Development Facilitation Team (DFT) – Review Comments

Project No: PR-2022-006674

Application For: SD-2023-00197-PRELIMINARY/FINAL PLAT (DHO)

REQUEST: INTERIOR LOT LINE ADJUSTMENT BETWEEN TWO EXISTING LOTS TO CREATE TWO NEW LOTS, SIDEWALK WAIVER FOR PATRICK AVE

**Plat for  
Lots 16-A and 17-A,  
Land of Raymond Ortiz  
Being Comprised of  
Lots 16 and 17,  
Lands of Raymond Ortiz  
City of Albuquerque  
Bernalillo County, New Mexico  
January 2024**

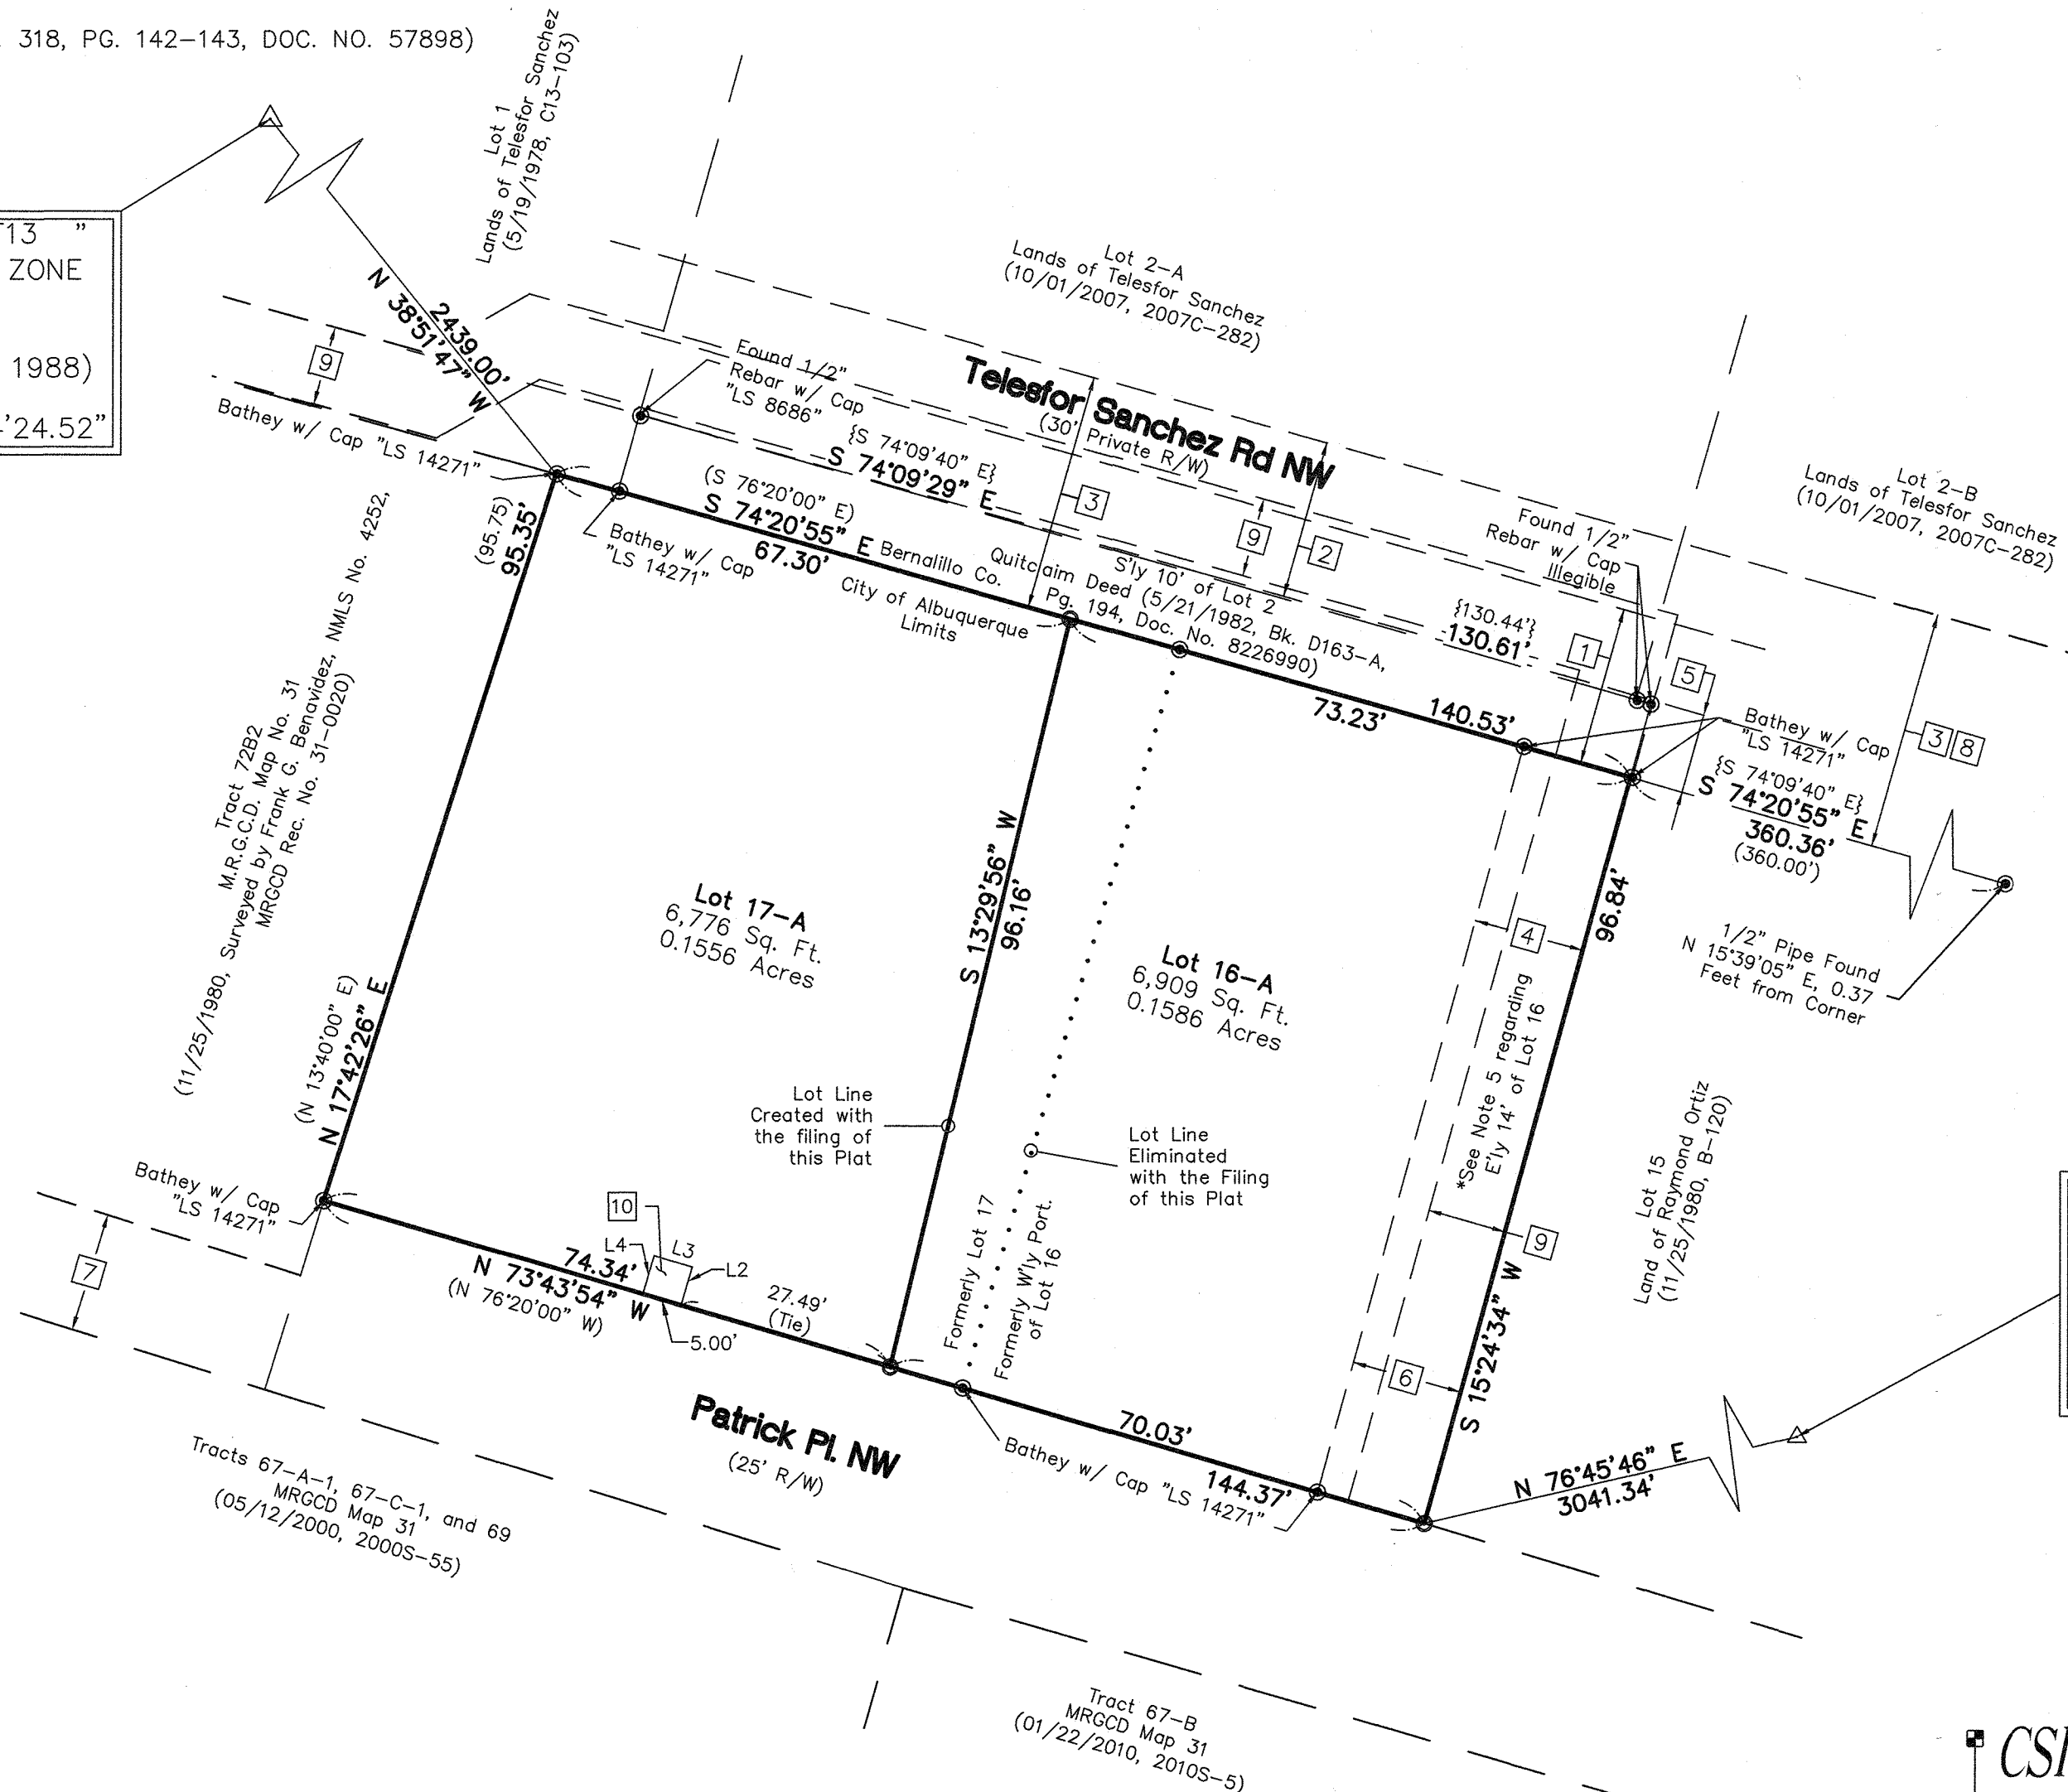
1. Lot 17-A: Lot Width required is 75 ft per Table 5-1-1 for RA-zone.
 - Lot 17-A Deviation of 4.2 feet proposed for width of Lot 17-A is recommended for approval.
2. Lot 16-A: Lot Width required is 75 ft per Table 5-1-1 for RA-zone. This lot appears to be legally non-conforming as to size, with an existing structure that also appears to be legally non-conforming. This would qualify for exceptions allowed under IDO 6-8(E), Non-Conforming Lots, and appears to meet the following requirement:

The Width is significantly less than the required 75 feet, and the proposed width reduces the extent of the existing non-conformity by both extending the width and taking the lot line outside of the existing structure.

3. Lot 17-A Deviation: Request deviation of 0.3 feet of the required 20 feet for the Front Setback of Lot 17-A, recommended for approval.
4. Lot 16-A: Deviation. Requested deviation of 0.9 feet for the West side setback of Lot 16-A. This is not required, as it is covered by Variance VA-2023-00284, allowing a reduction of 1 foot to the 10 ft Side Yard Setback of Lot 16. Deviation note should be removed and replaced with the applicable Variance note.

5. Lot 16-A East side yard setback is deficient, showing 8.4 ft of a required 10 ft setback. However, as this structure appears to be an existing nonconforming structure, the existing non-conforming side setback is allowed to continue under IDO 6-8(D) Nonconforming structures, with the following condition outlined as per IDO 6-8(D)(4), regarding future addition or enlargement:
*6-8(D)(4) Setback Nonconformance
A structure nonconforming as to setback regulations cannot be added to or enlarged unless the addition conforms to all the regulations of the zone district in which the structure is located.*
